CITY OF ALBUQUERQUE

May 30, 2018

RE: **Holly Hotel**
5900 Holly NE
Requested for Permanent C. O. – Not Accepted
Engineers Stamp Date 4/22/16 (C18D073B)
Certification dated: 4-9-18

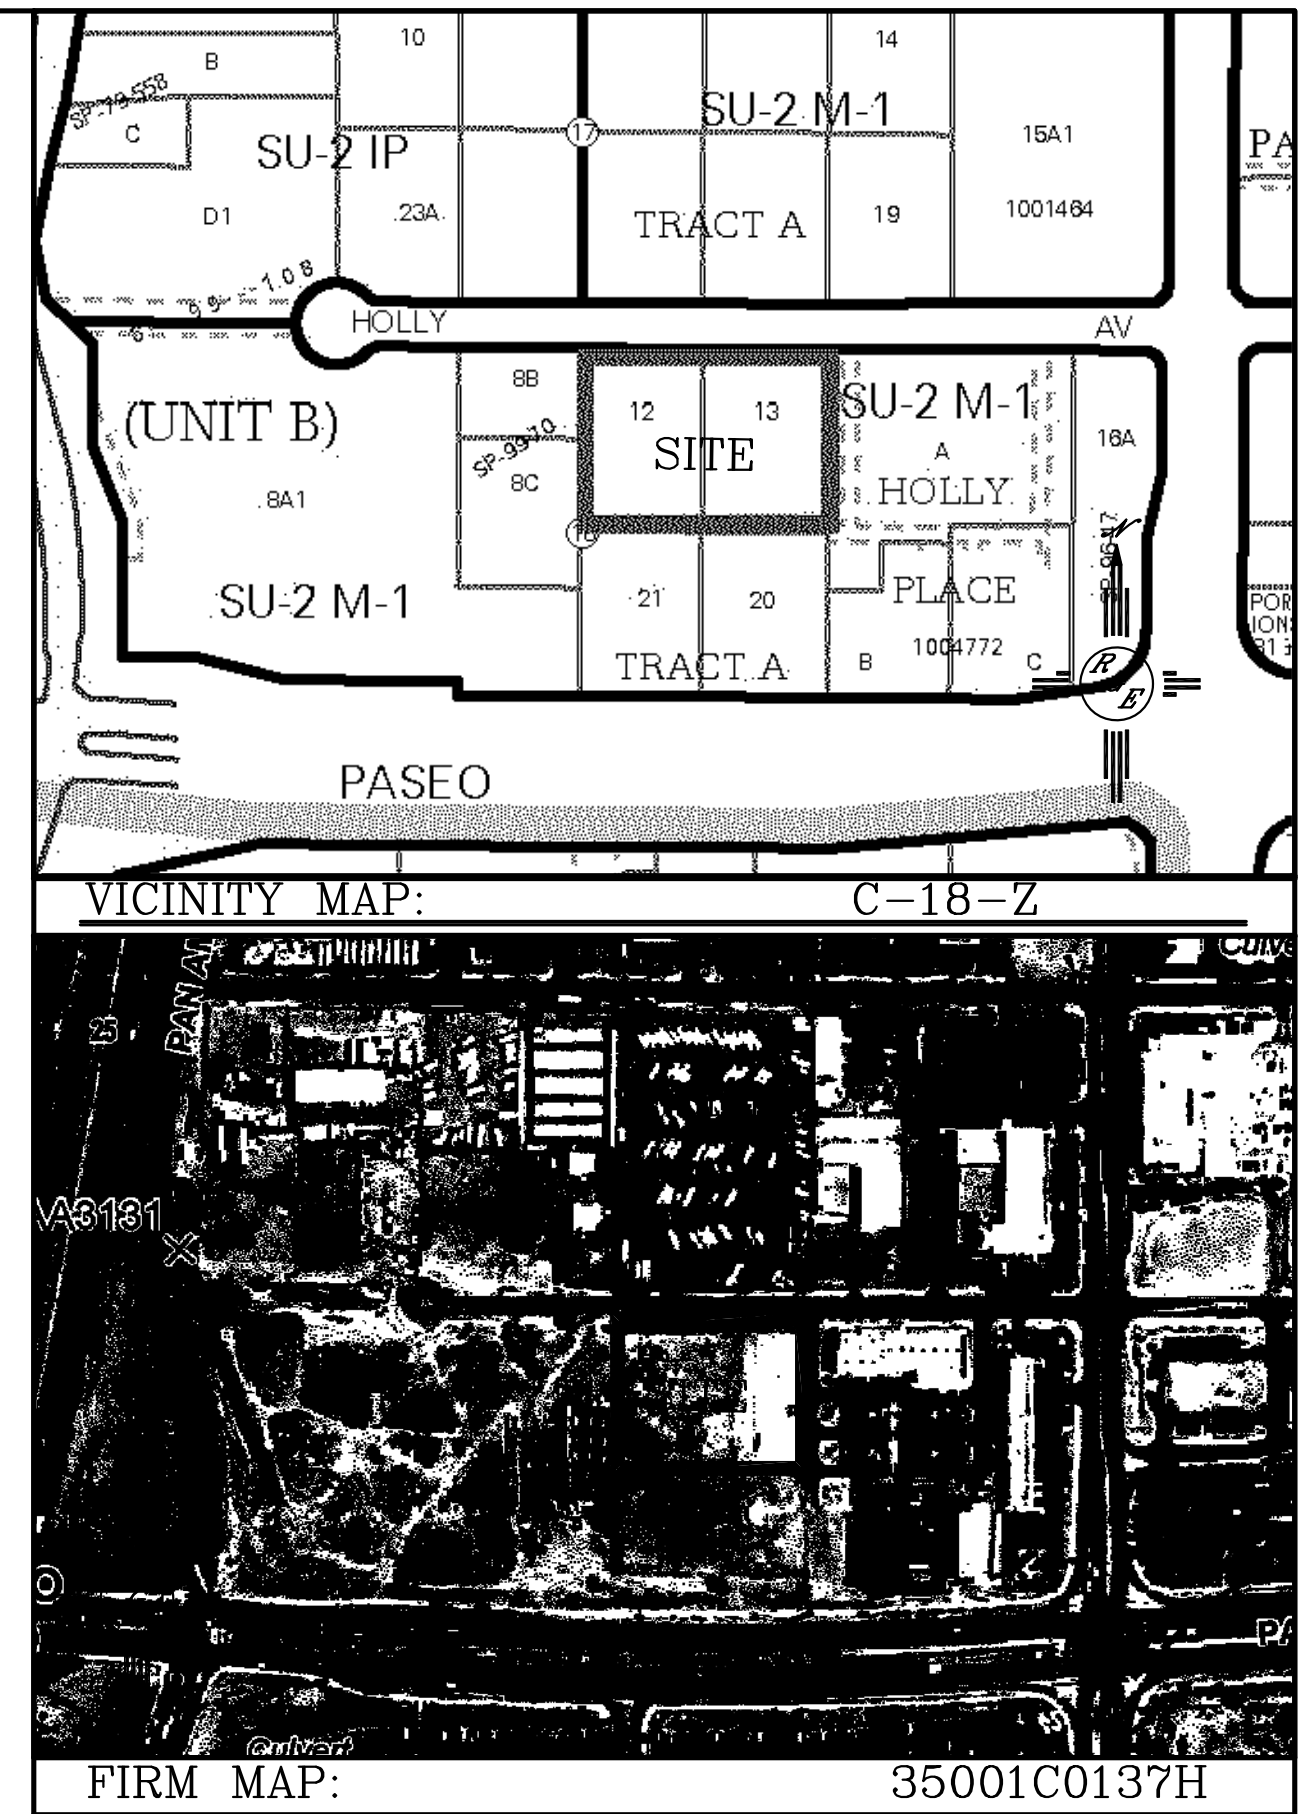
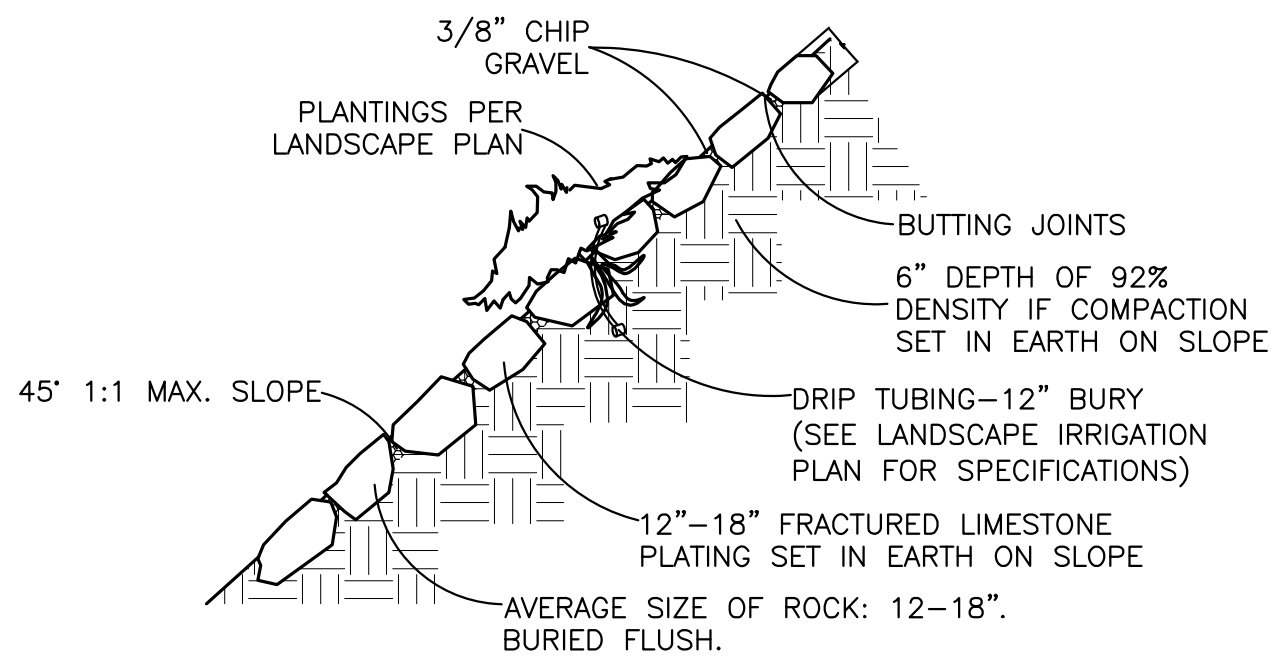
- The 234' LF of CMU block wall with grout to act as a flood wall is missing.
- The Private Facility Drainage Covenant is required for the maintenance of the first flush facilities.
